NSW RURAL FIRE SERVICE

Your reference: SSD-10479
Our reference: DA20200706002398-EIS & DA
Exhibition-1

Development Application
State Significant – EIS & DA Exhibition – Industry
Industrial Estate 200 Aldington Road Kemps Creek NSW 2178, (none)

The NSW RFS has reviewed the information provided in relation to the State Significant Development of proposed Warehouse & Logistics Hub including Stage 1 works on the subject site, and recommends the following conditions:

**Figure 9 – Plan of Defendable Spaces.**

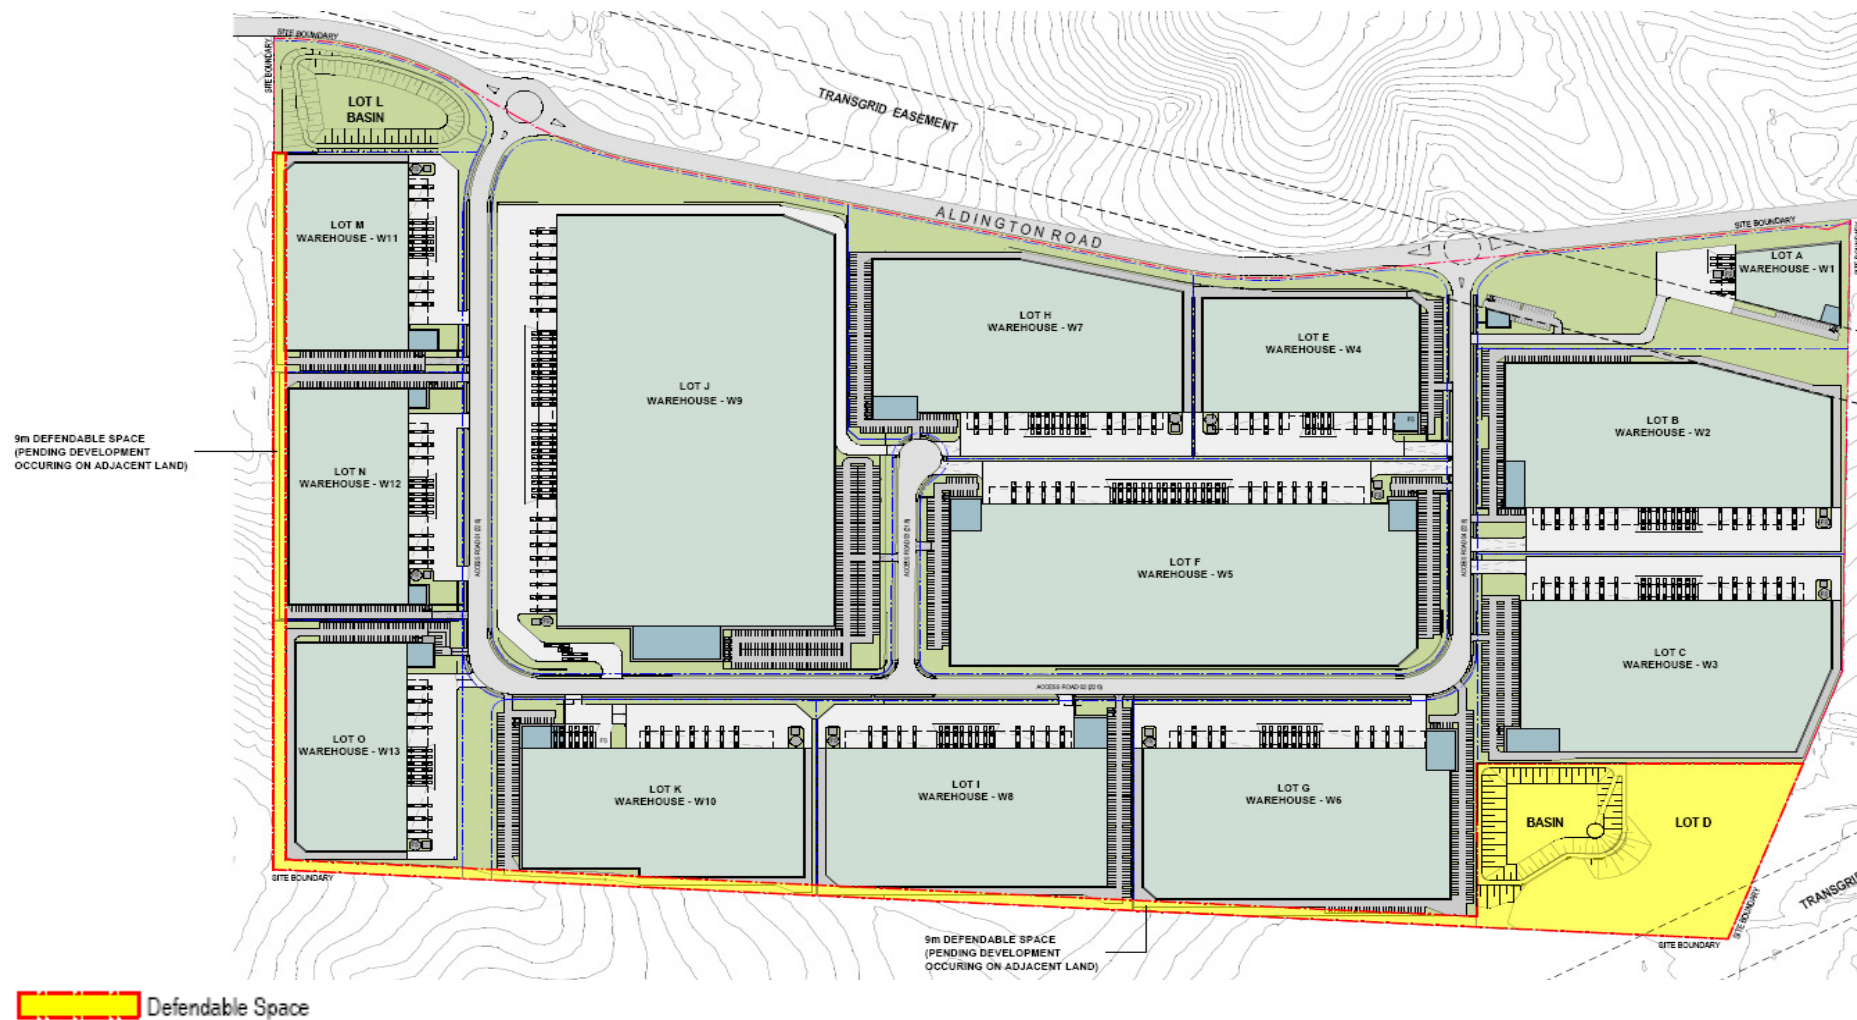
1. A Vegetation Management Plan must be prepared to include measures to establish the maintenance of the vegetation management area within proposed Lot D as demarcated on Fig. 3 of the Biodiversity Development Assessment Report (prepared by Eco Logical Australia, Project Number 20SYD16452, Version 2, dated 15 October 2020). The restoration and revegetation of the vegetation management area shall not exceed fuel loads of 22/36.1 t/ha as per Table A1.12.8 of *Planning for Bushfire Protection 2019*.

2. From the start of building works, and in perpetuity to ensure ongoing protection from the impact of bush fires, all the proposed industrial lots within the subject site, except Lots D and L demarcated for drainage basin, must be managed as an inner protection area (IPA) in accordance with the requirements of Appendix 4 of *Planning for Bush Fire Protection 2019*.
